**Green Square Integrated
Community Facility & School**
3 Joynton Avenue
Zetland NSW 2017

**ACCESSIBILITY
REPORT**

Our Ref: AN020-215729
Date: 23/07/2021

GA PLAN - LEVEL 02

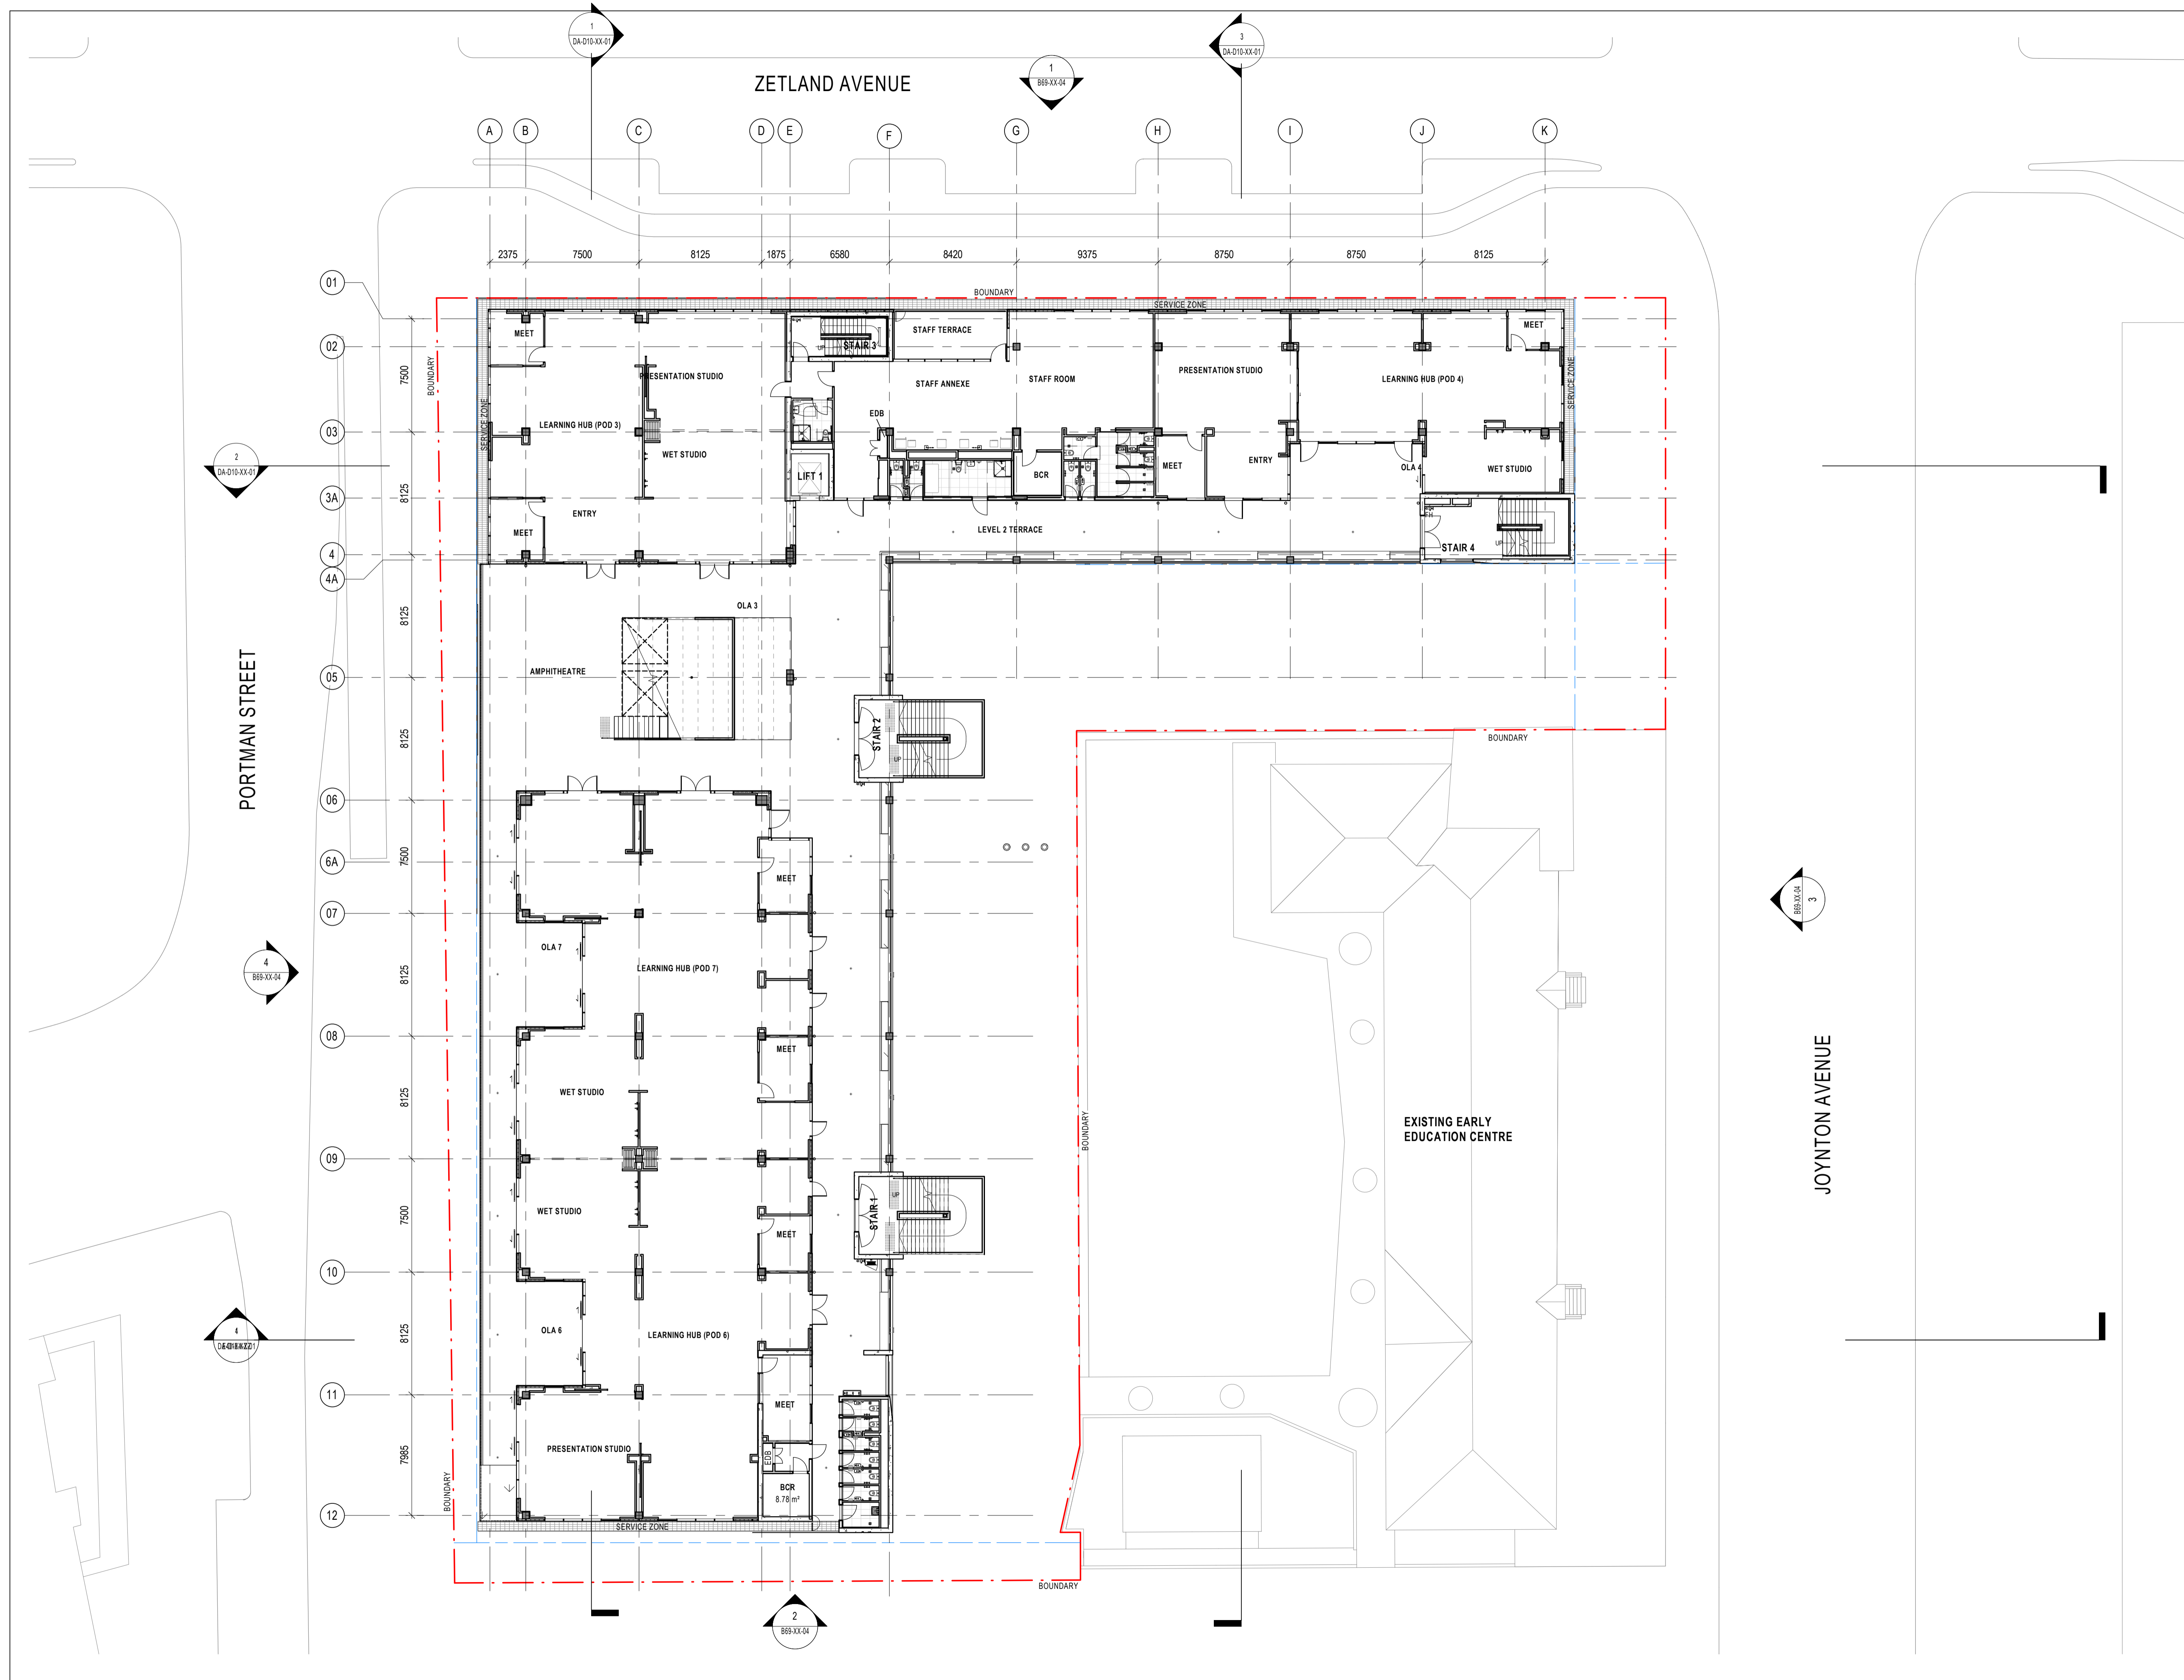
- c) There is a vestibule along a required accessway outside the unisex accessible sanitary compartment on level 02, that can be modified to accommodate minimum 1450mm clearance between the successive door swings for compliance with AS1428.1-2009 and to provide access to and within all areas in accordance with BCA D3.1.

- e) There is an unisex accessible sanitary compartment proposed on level 02 that can be increased in overall all dimensions (e.g. min. 2350mm wide by 2750mm long), to accommodate all the required circulation spaces around a pan, basin and shower for compliance with AS1428.1-2009 as required by BCA F2.4.

GA PLAN - LEVEL 03

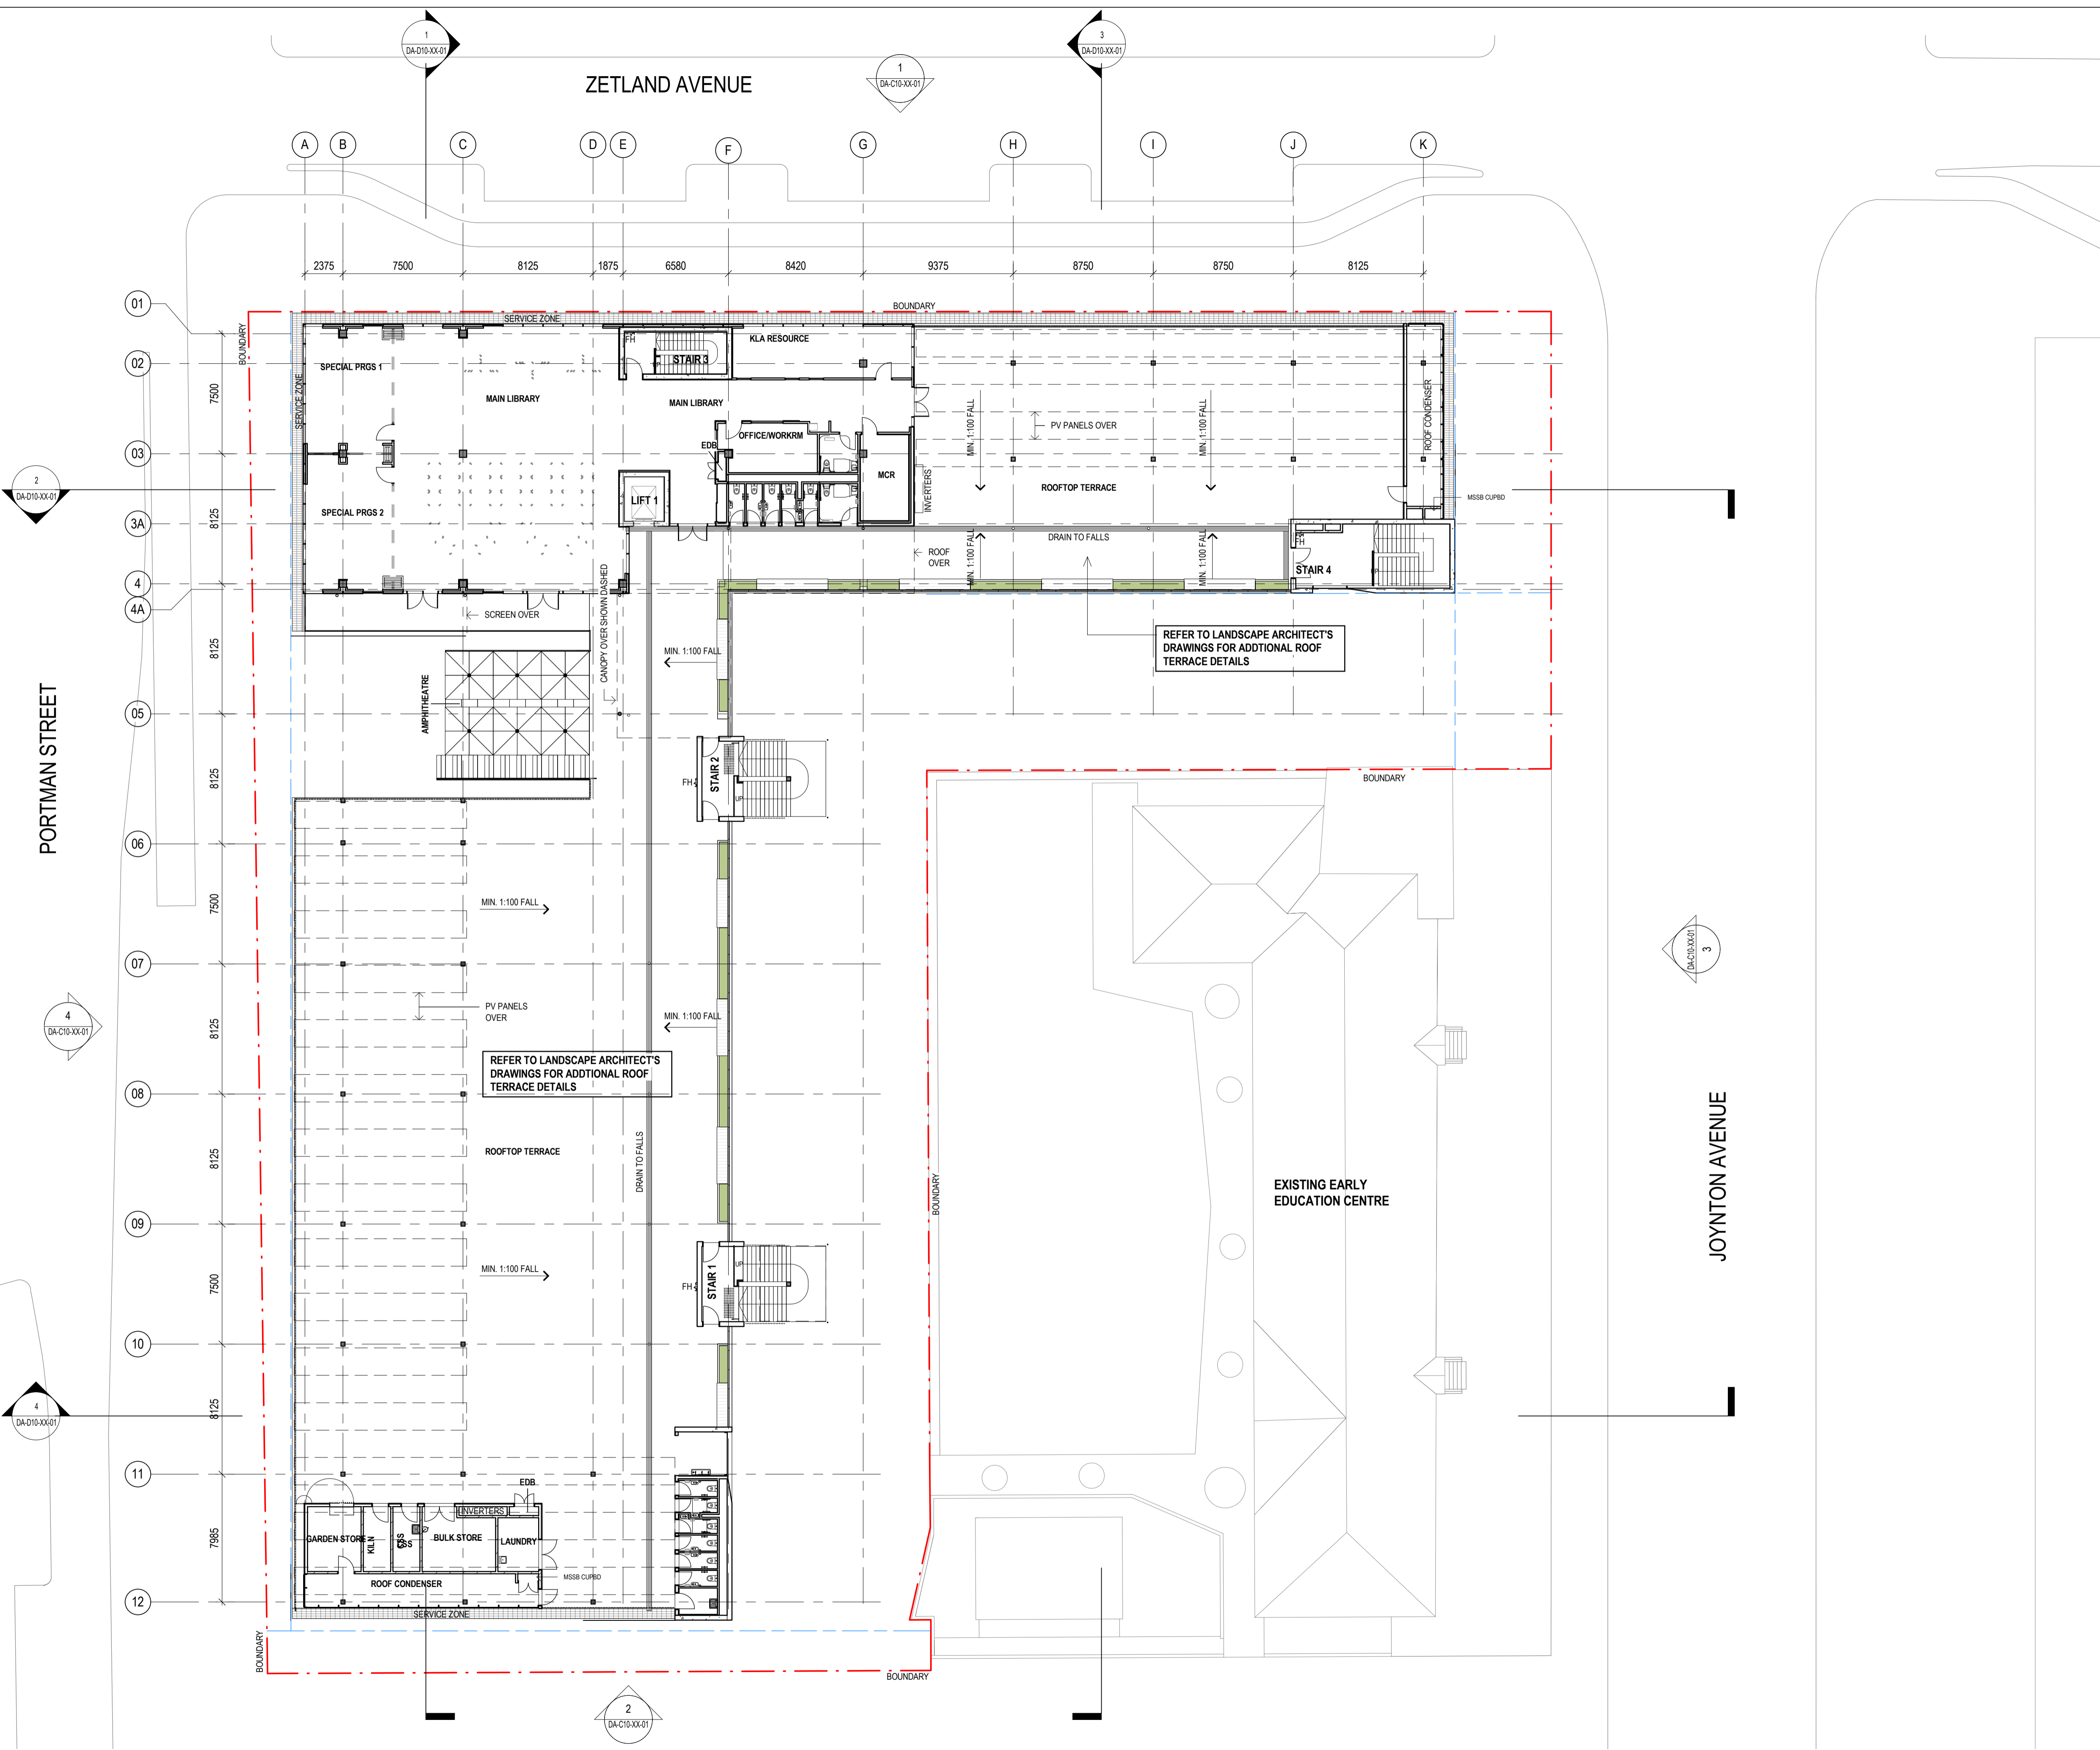
- b) There are multiple doorways along required accessways on ground floor, levels 1 and 3 of the new school building that can be increased in door circulation spaces for manual operation and/or that can be on power operation or automation for compliance with AS1428.1-2009 and to provide access to and within all areas in accordance with BCA D3.1.

**2 PLAN - DETAIL OF BAL-105 AND EXTERNAL  
STAIR TO MULTIPURPOSE 1A & 1B**  
1:10

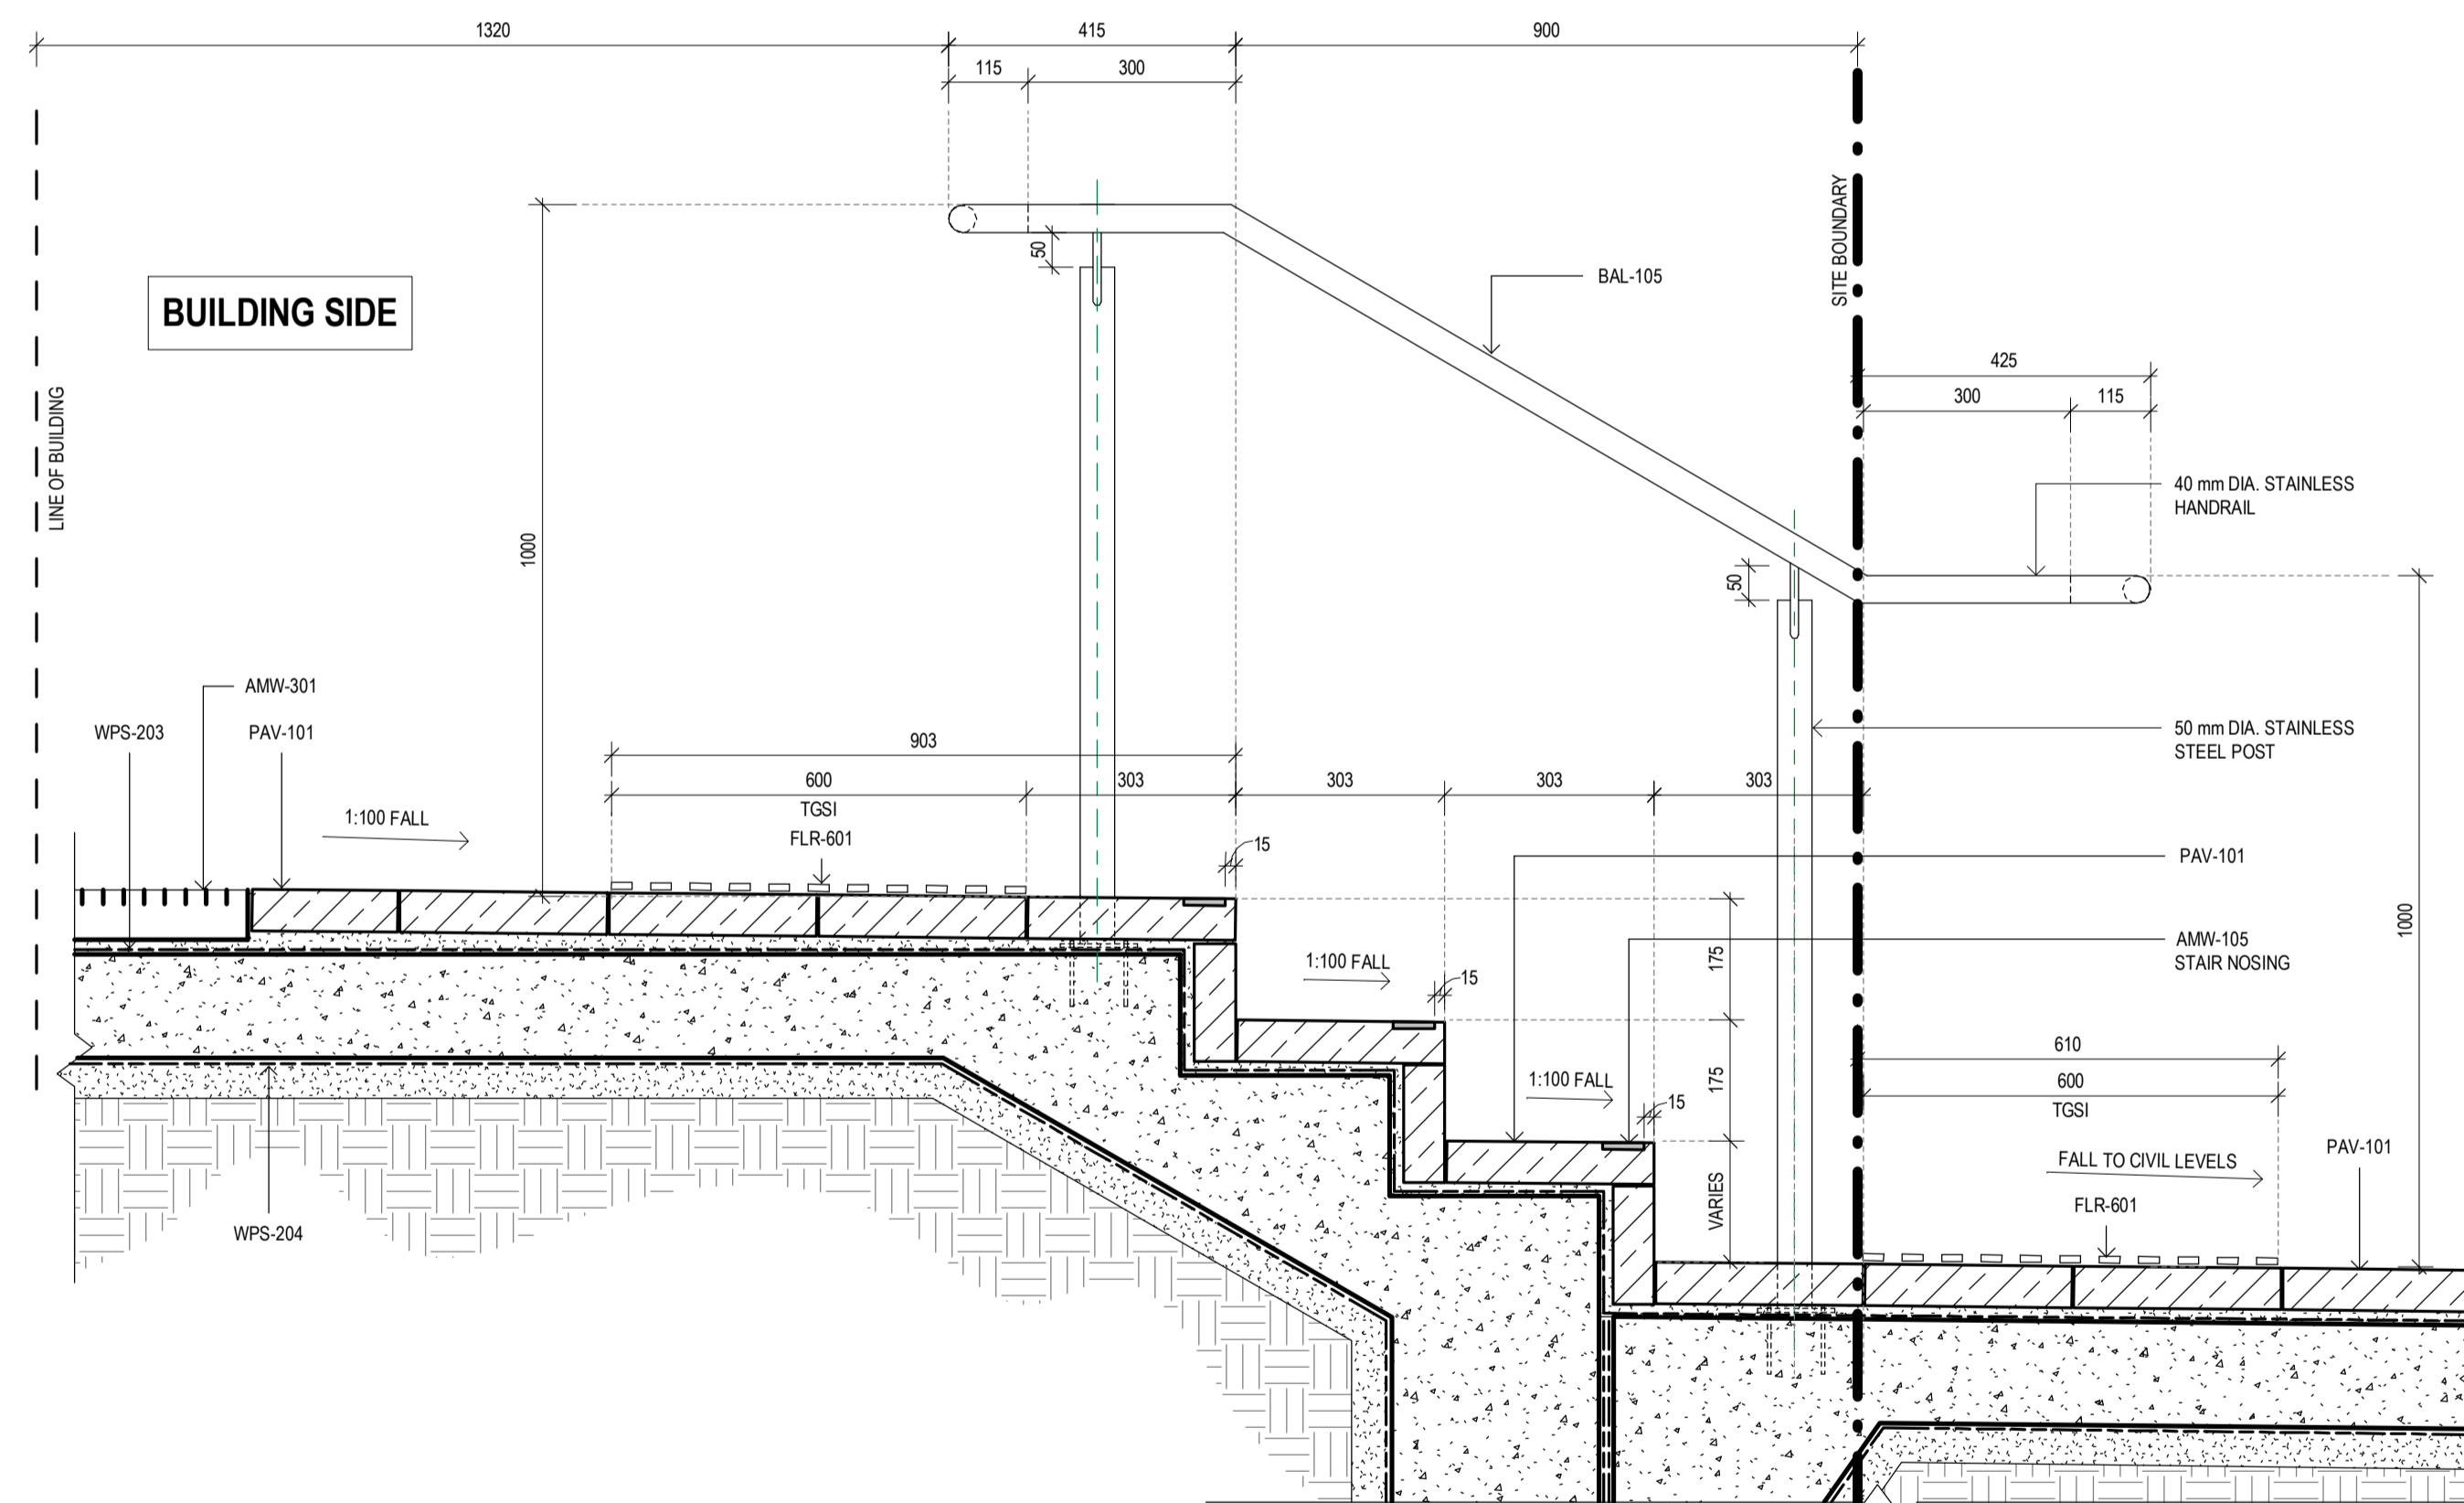
- d) An additional performance based solution is possible and may be required for handrail set outs on the external domain on the ground floor along northern Zetland Avenue boundary outside Multipurpose 1A and 1B.
